Re: Planning App. No. N6/2012/2194/FP Campus West

I refer to the above application for retrospective planning permission. I make the following comments:

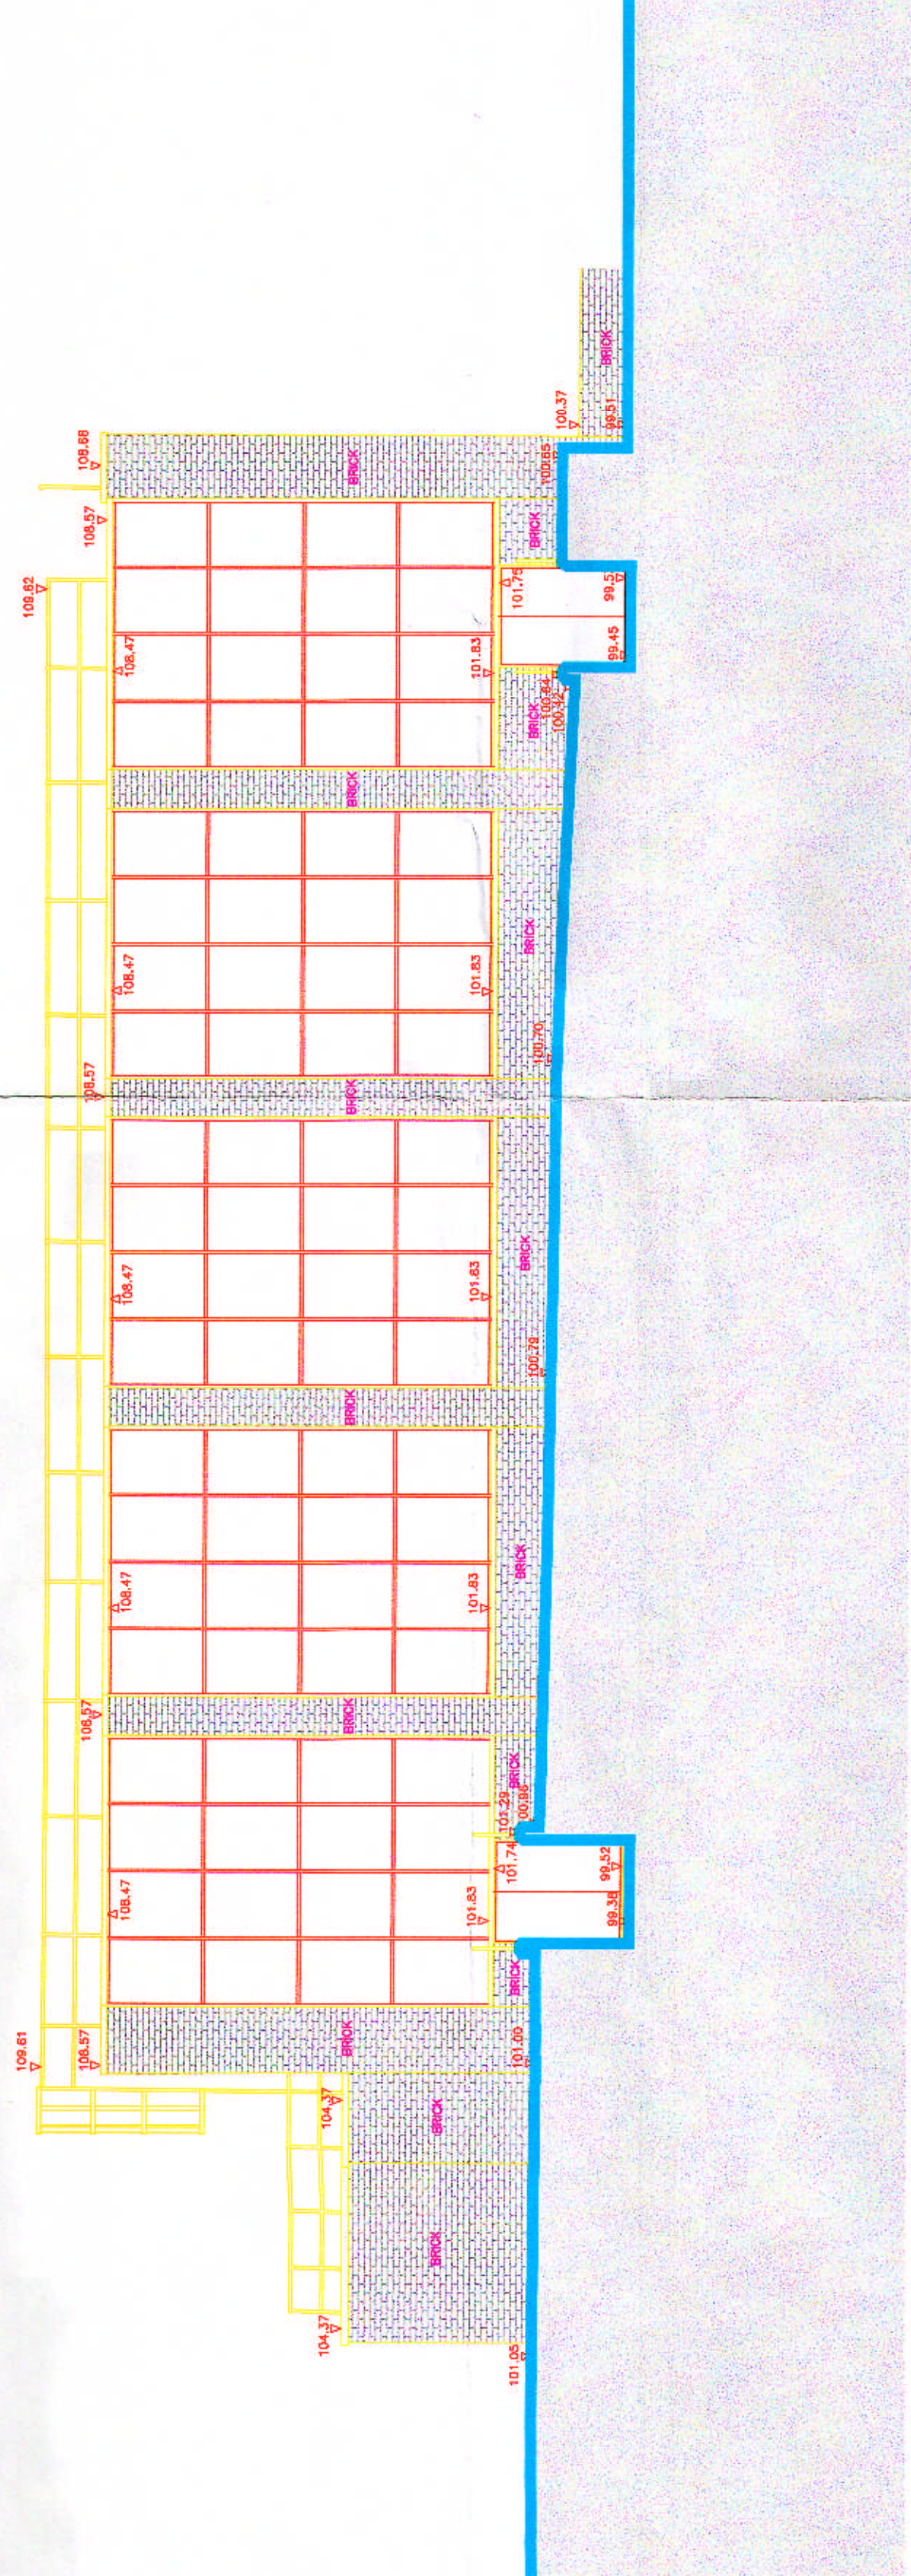
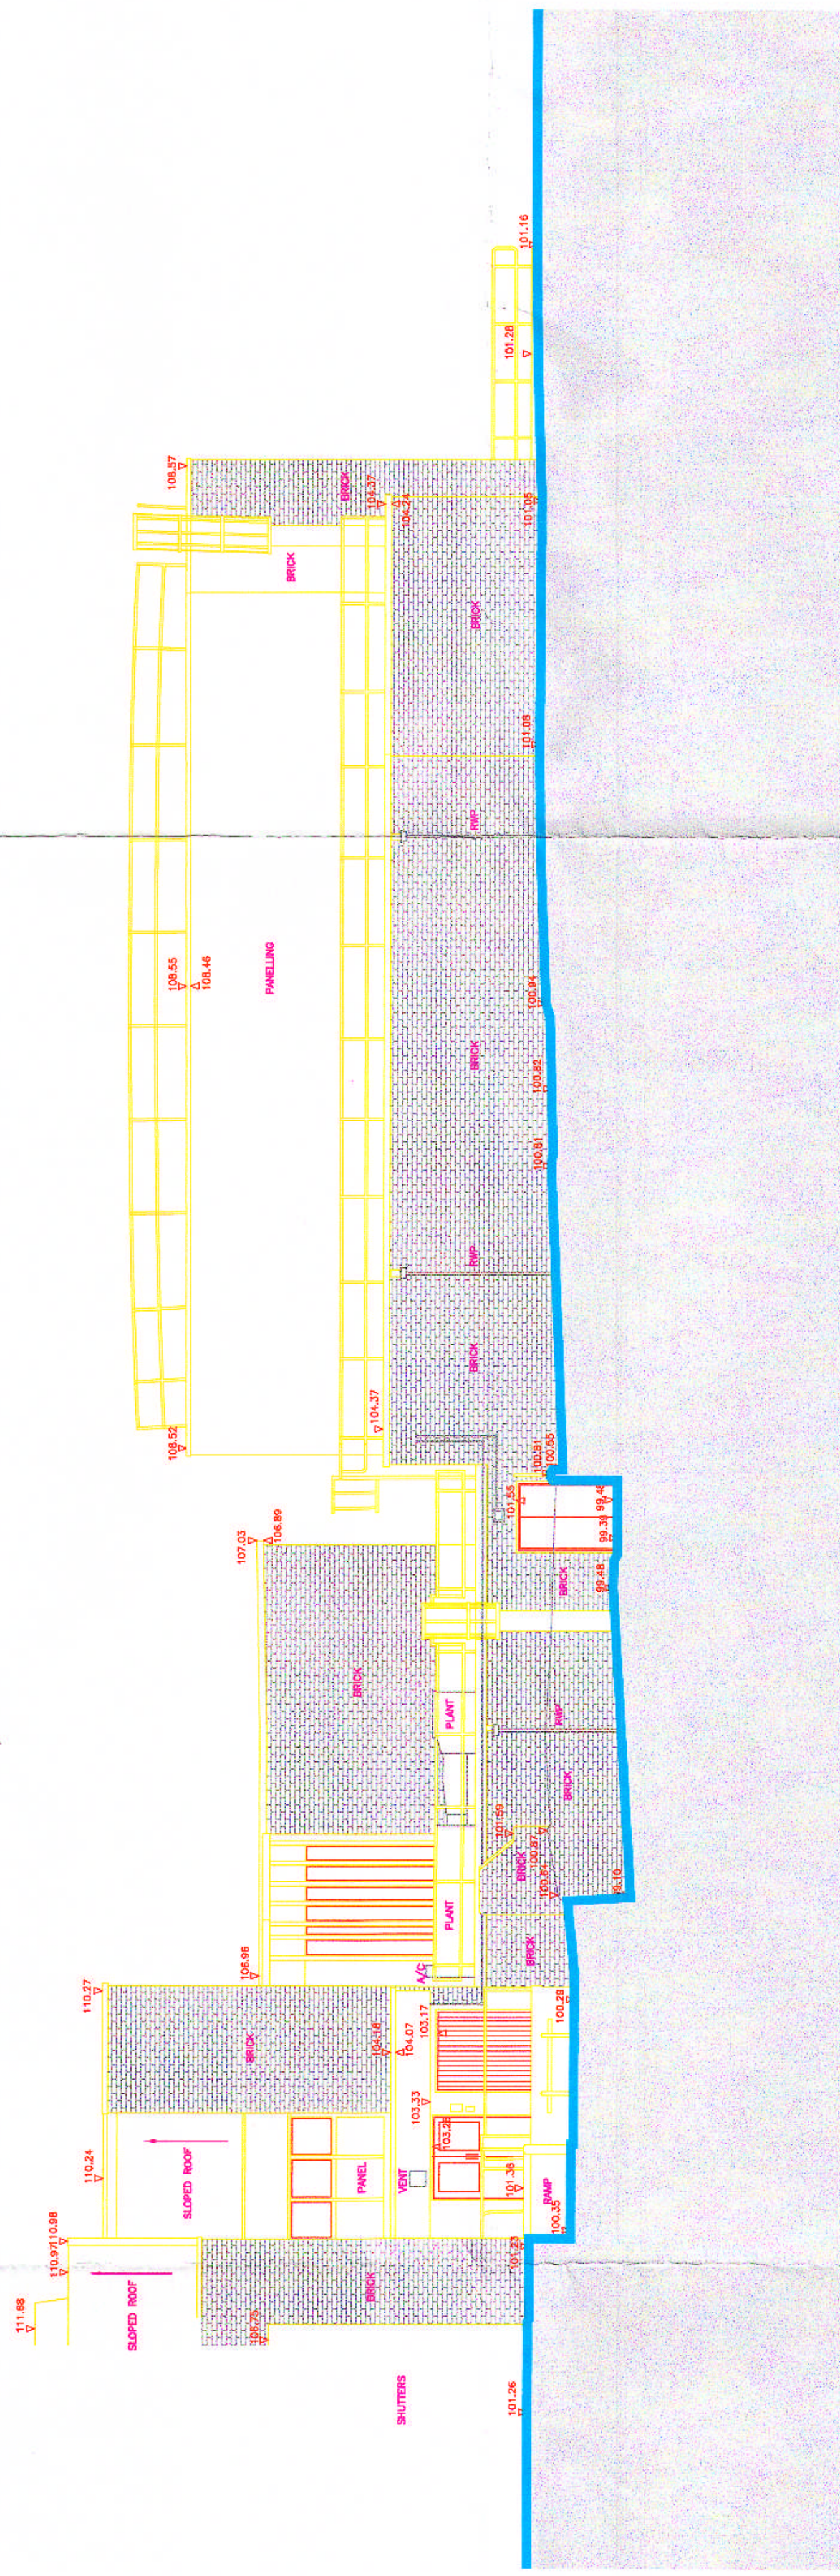
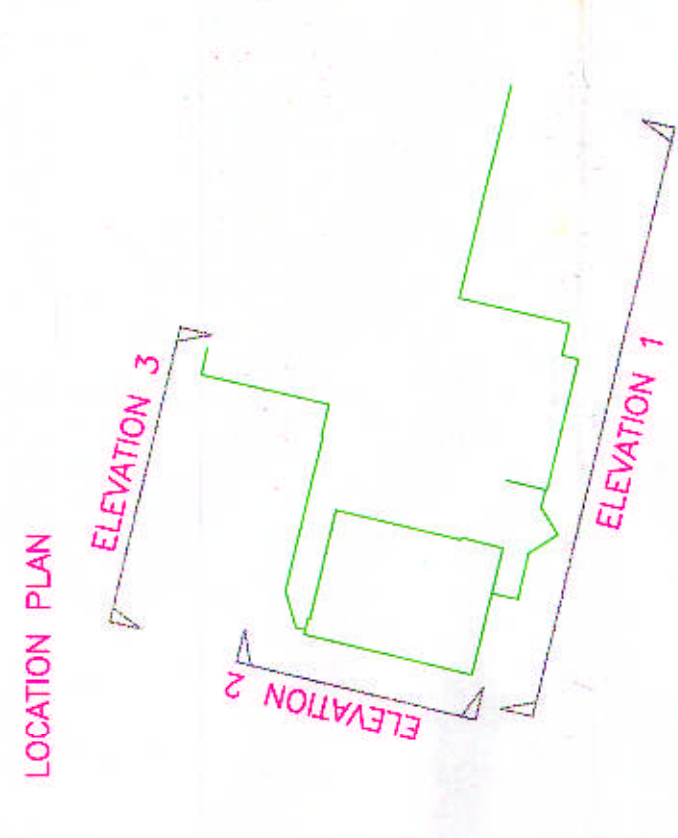
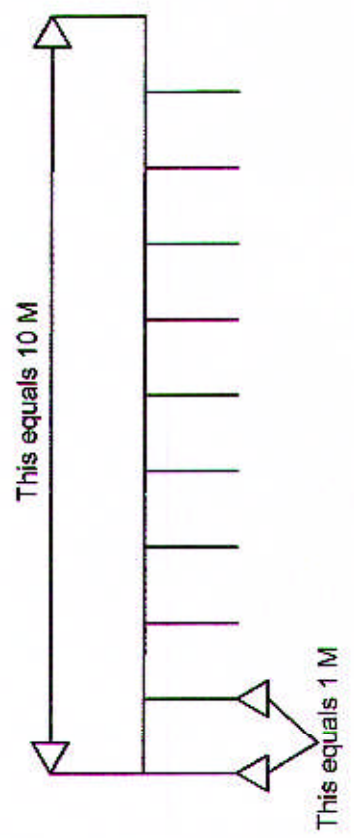
2. The new railings installed are unsightly and only galvanised and not painted. The joints connecting the poles are like scaffolding joints and are ugly.

5. The new guard rails are not straight and therefore very unsightly particularly at the front of the building. This may well be because the roof curves however if bespoke railing was made to measure and installed, I am sure the curve in the railing could be avoided.

I therefore object to the planning application for retrospective planning approval for the galvanised railings and ladders. Bespoke railings and ladders painted in the same blue colour should be installed at the property.

drawing  
**Campus West  
Roller City Roof**

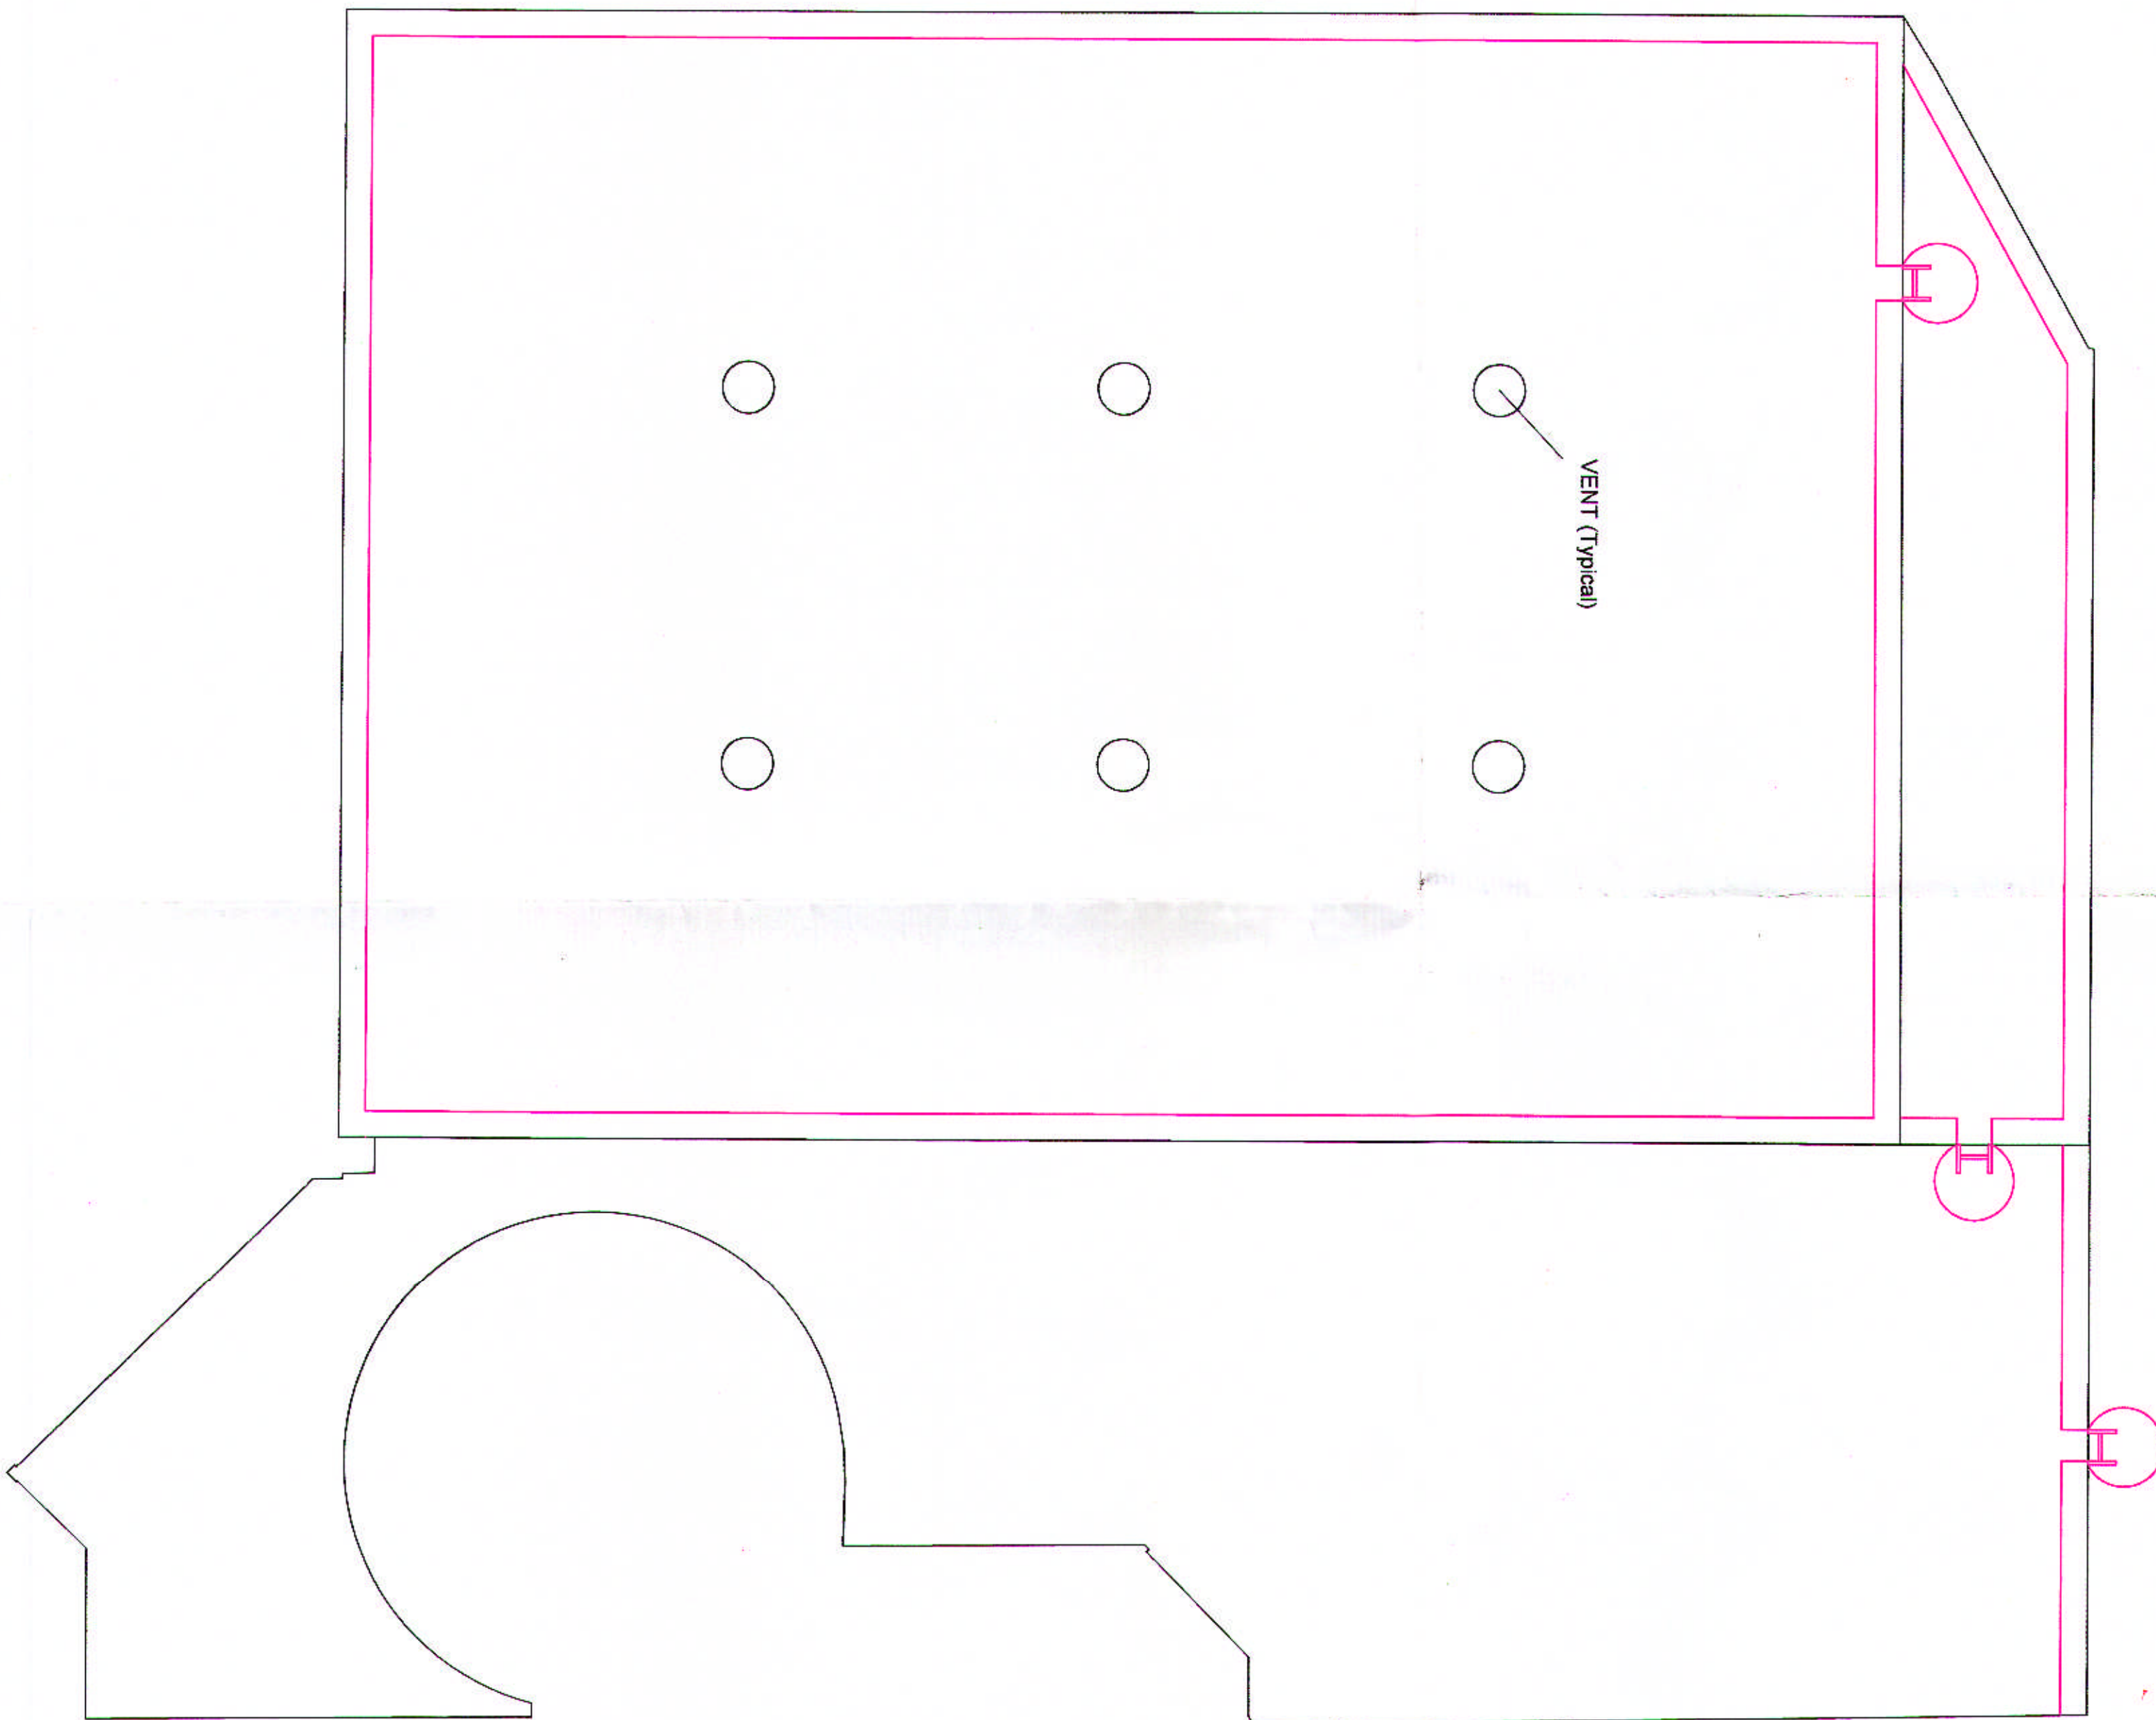
7. The property is in a conservation area and therefore any alterations and additions should be in keeping with the surrounding area and style of any existing building. This has not happened with the railings and ladders presently installed. Further, planning permission should have been sought before the work was carried out.
